Consultation Response from Emma Mills KC Landscape

Application No:	2021/91914
Proposed Development:	Demolition of one dwelling, erection of 45 dwellings with access and associated infrastructure
Location:	rear of, 28, Northorpe Lane, Northorpe, Mirfield, WF14 0QN
Applicant/Agent:	Johnson Mowat Planning Ltd
Planning Officer	Richard Gilbert
Date Responded:	19.01.22
Responding Officer:	EM
Responding Ref:	KK58 rev A

Proposed Site Layout

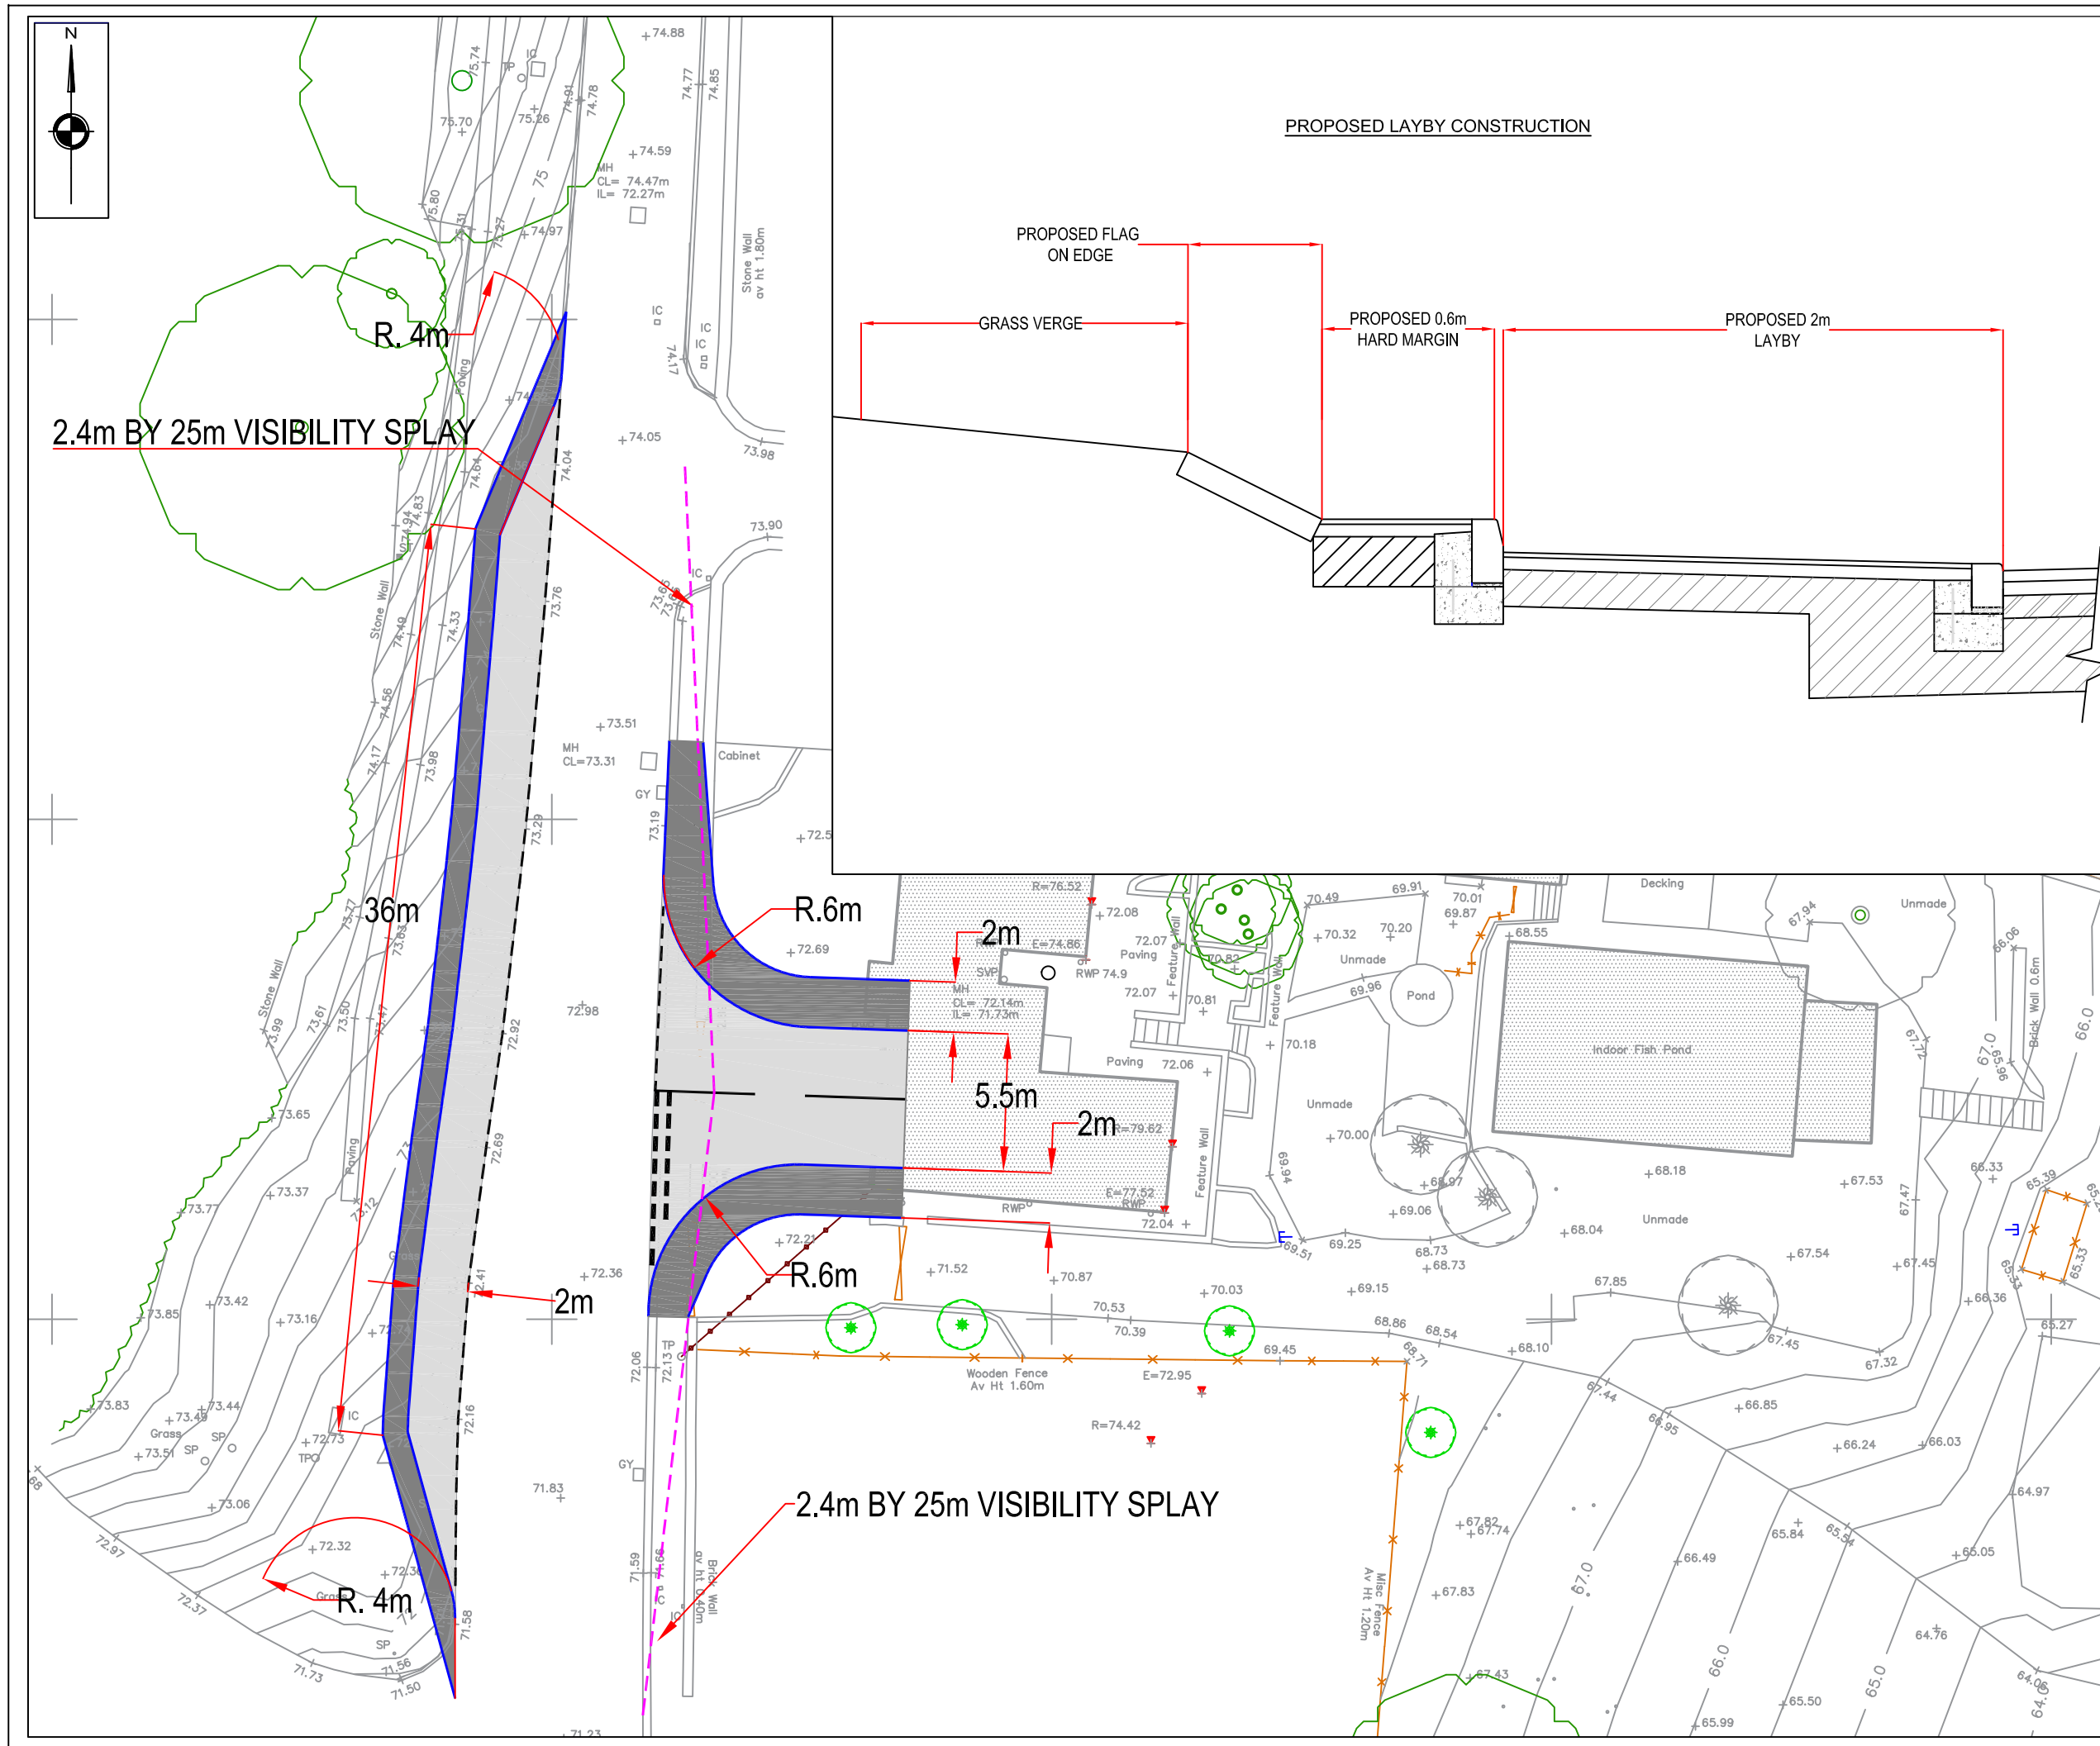
Amenity Open Space (AGS) (magenta boundary below) = 853m² (of which 577m² is off site across the road) 276m² provided on site
Natural and Semi Natural POS (cyan boundary line below) = 864m²

Clarification required as to whether the existing grassed area across the road (incorporated for layby) is eligible for POS as per LP63, if it is within land ownership/redline boundary etc. given part of it is not registered with land registry.
